From: clerk@sabdenparish.org.uk
Sent: 03 February 2021 22:58
To: Planning
Cc: Rebecca Bowers; Cllr R Newmark
Subject: Planning application 3/2021/0032

Planning Application 3/2021/0032 Replacement of unauthorised existing flat roof with a new pitched roof over a ground floor south facing rear outrigger. At 2 Pendle St West Sabden

Drawing Title			
Proposed Eaves Detail			
Project			
2 Pendle Street West, Sabden			
Client			
Jigsaw Homes Group			
Scales @ A2		First Issue Date	Drawn
1:20		06 / 10 / 2020	BB
Job Number / Dwg. No. / Revision		RIBA Stage - Drawing Status	
L2980_GA05_A		[3] - Planning	
Checked		By	
Date		Date

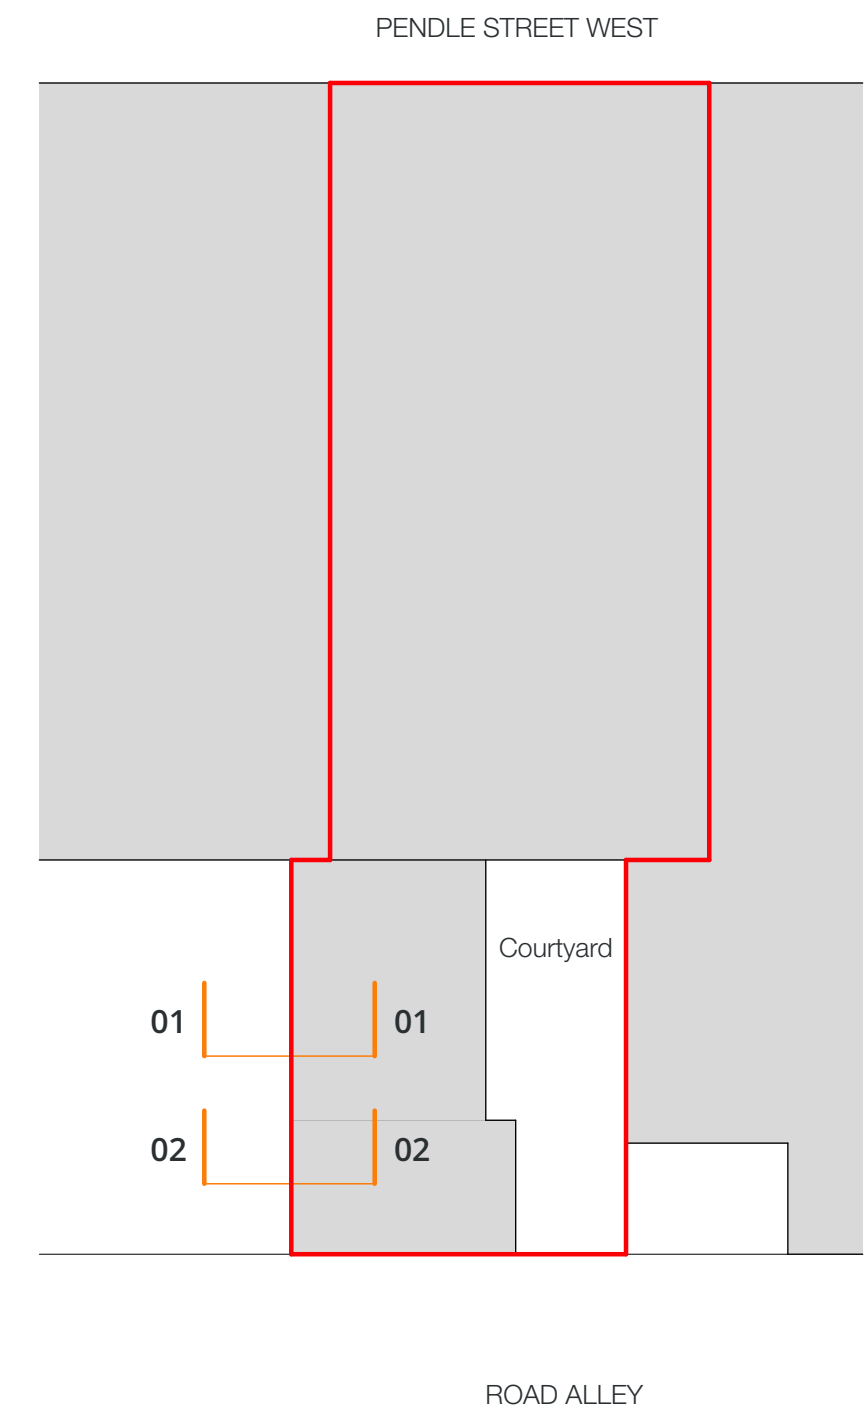
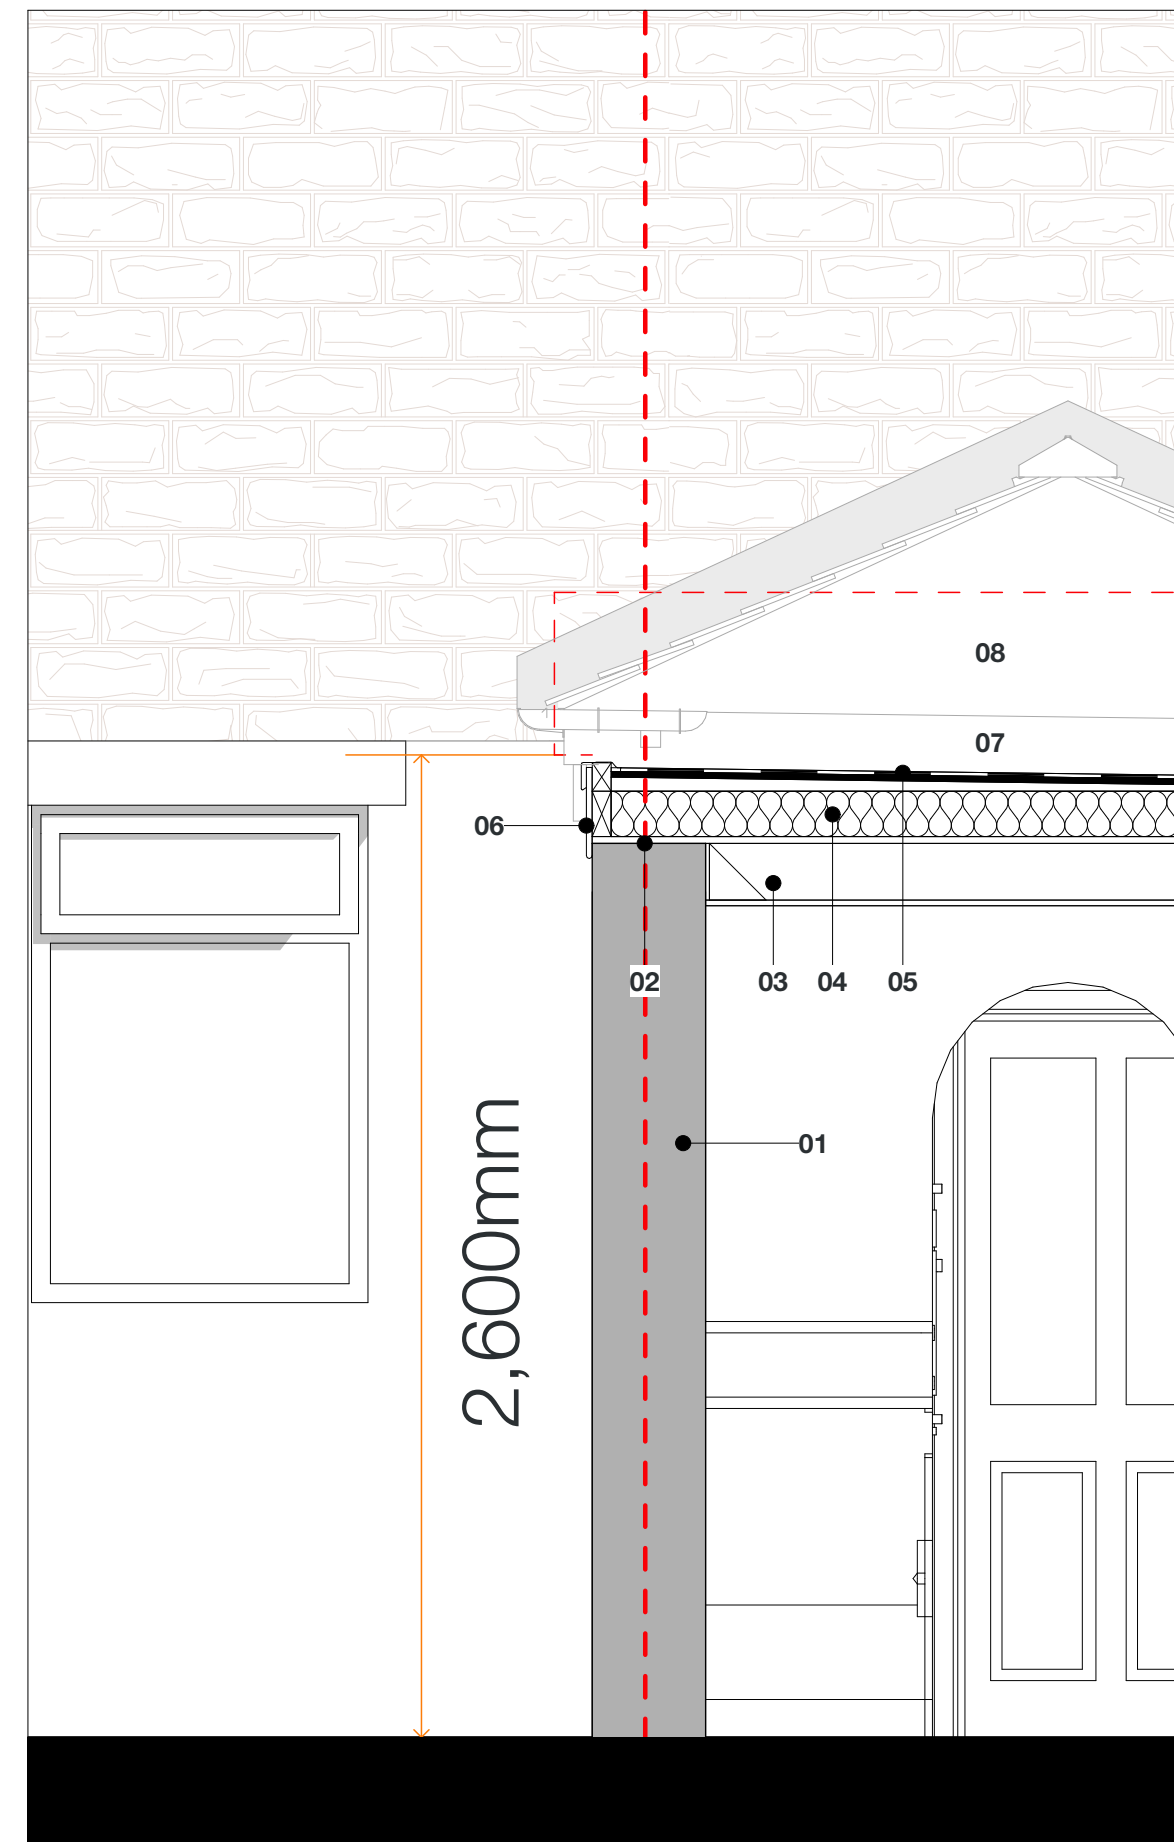
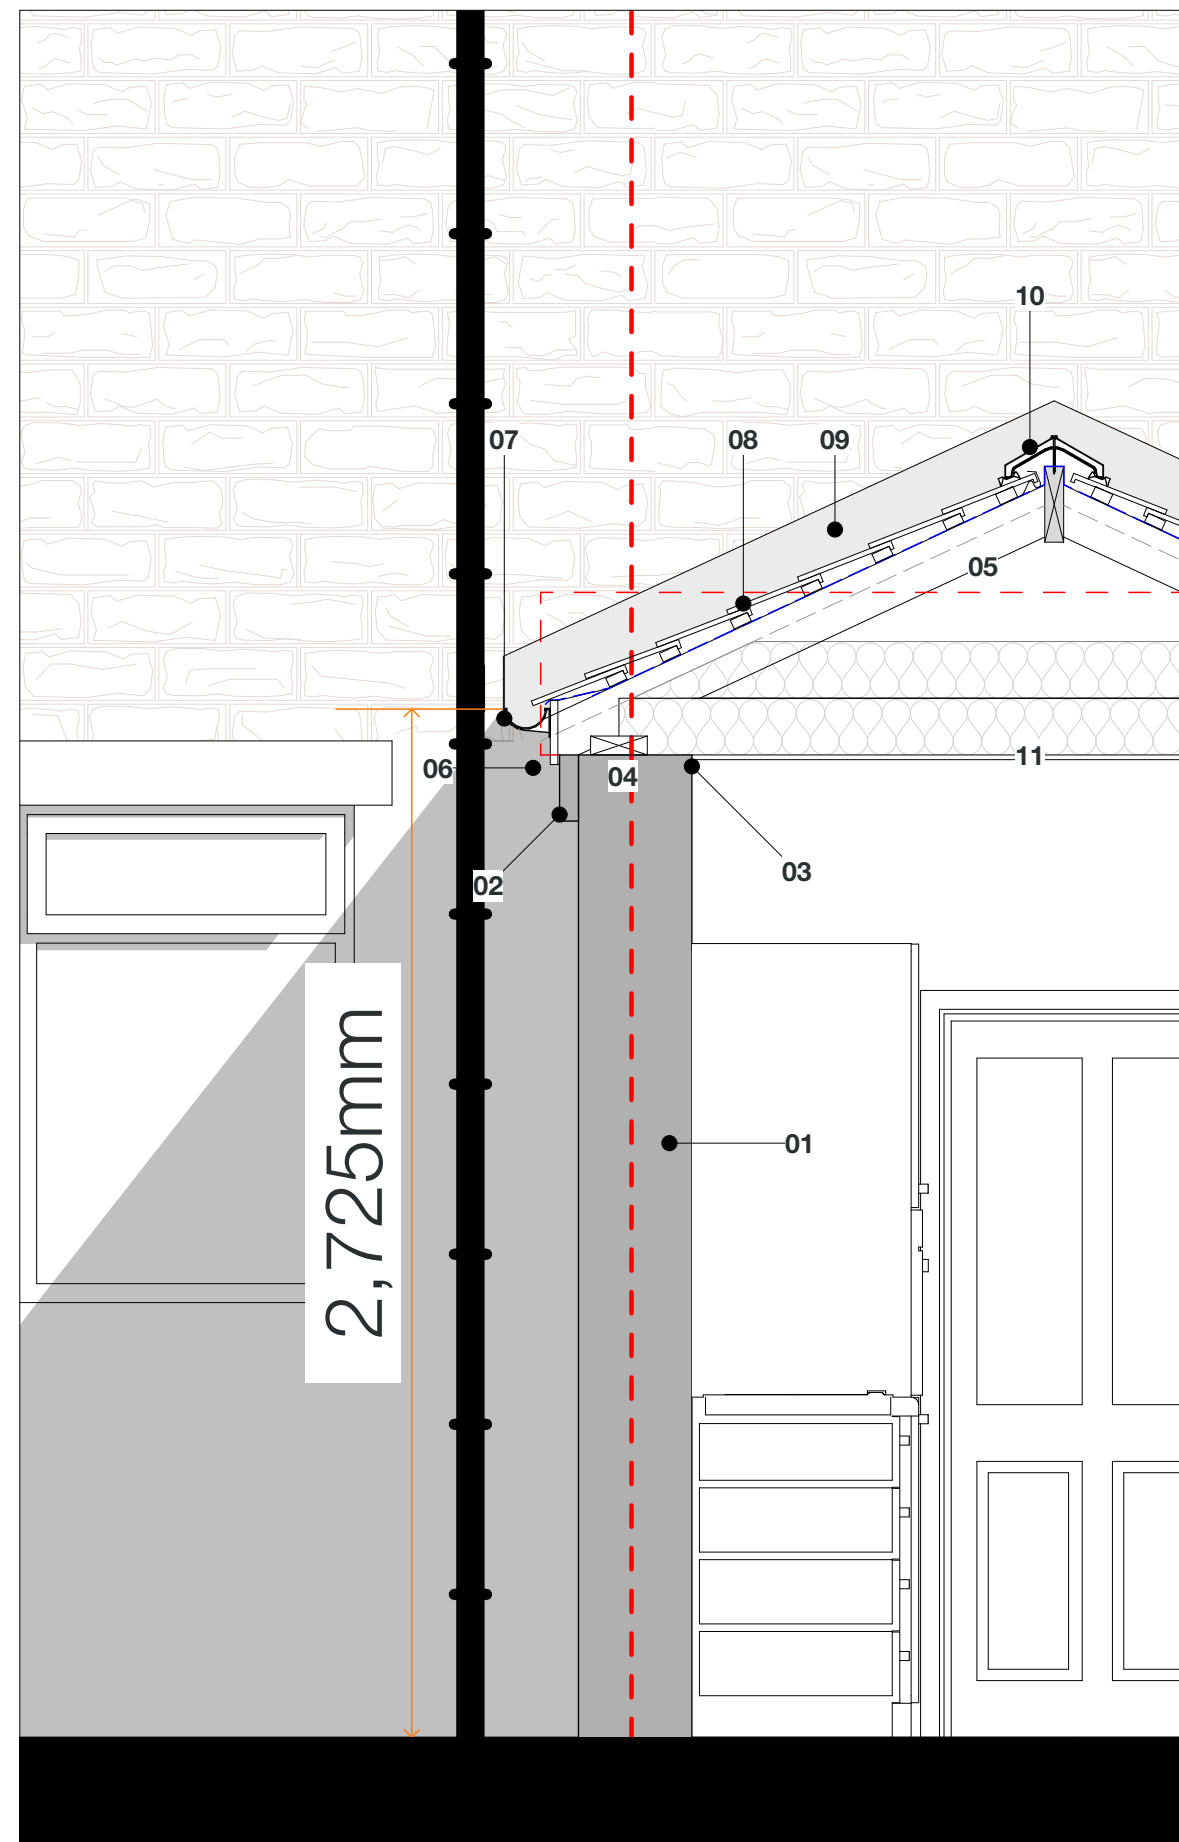
The plans show the fascia boards overhanging the party wall into the neighbouring property
